EN010117: Application by Rampion Extension Development Limited for the Rampion 2 Offshore Wind Farm

The Examining Authority's Written Questions and requests for information

Issued on Wednesday 3 April 2024

Figure 2.3 Great black-backed gulls (red circles) perched on WTG in the non-breeding season (February 2021)

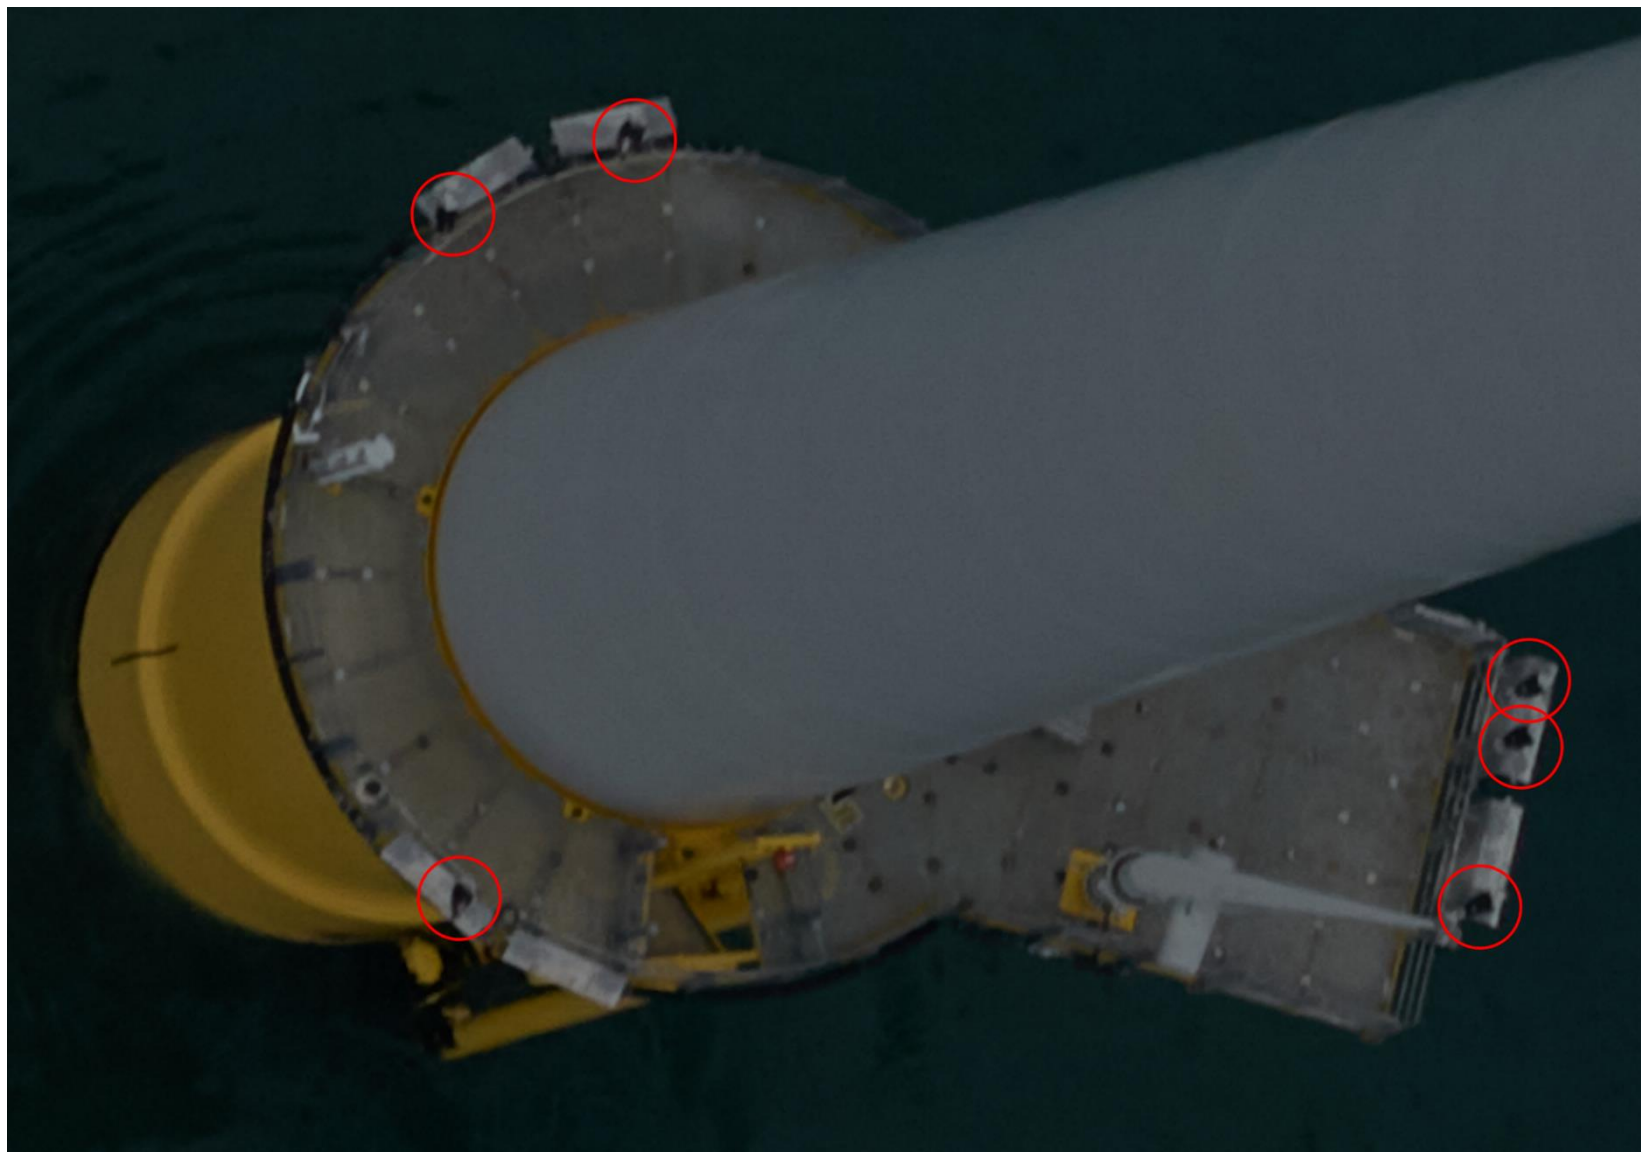
HRA 1.6	<p><i>Great Black-backed Gull UK South-west & Channel BDMPS Regions</i></p> <p>The Applicant</p>	<p>a) Respond to Natural England's comments at Deadline 2 [REP2-040] on the Applicant's updated approach to assessing the potential cumulative impact on the great black-backed gull within the UK South-west & Channel BDMPS regions, specifically comment on Natural England's comments on the Applicant's:</p> <ul style="list-style-type: none">i. Revised approach collision risk modelling [REP1-038].ii. Calculation of the breeding season population.iii. Inclusion of overseas birds.iv. Calculation of the Southwest UK and Channel breeding season reference population to include colonies in the west of Scotland.

<p>b) Respond to Natural England’s recommendation [REP2-040] to use the non-breeding season BDMPS population scale to more accurately reflect the potential cumulative effects on the relevant population.</p>
HRA 1.7	<p><i>Potential for Adverse Effect on Integrity (AEoI) to the Conservation Objectives of the Northern Pintail of the Arun Valley Ramsar site</i></p> <p>Natural England</p>	<p>In light of the Applicant’s responses at Deadline 1 [REP1-017] to Natural England’s concerns [RR-265] regarding the foraging range of the northern pintail, potential impacts from habitat fragmentation and potential temporary loss of functionally linked land of the Arun Valley Ramsar site, state:</p> <p>a) Whether the Applicant’s responses address Natural England’s concerns.</p> <p>b) What further assessment and / or mitigation is the Applicant advised to undertake / implement to address Natural England’s concerns.</p>
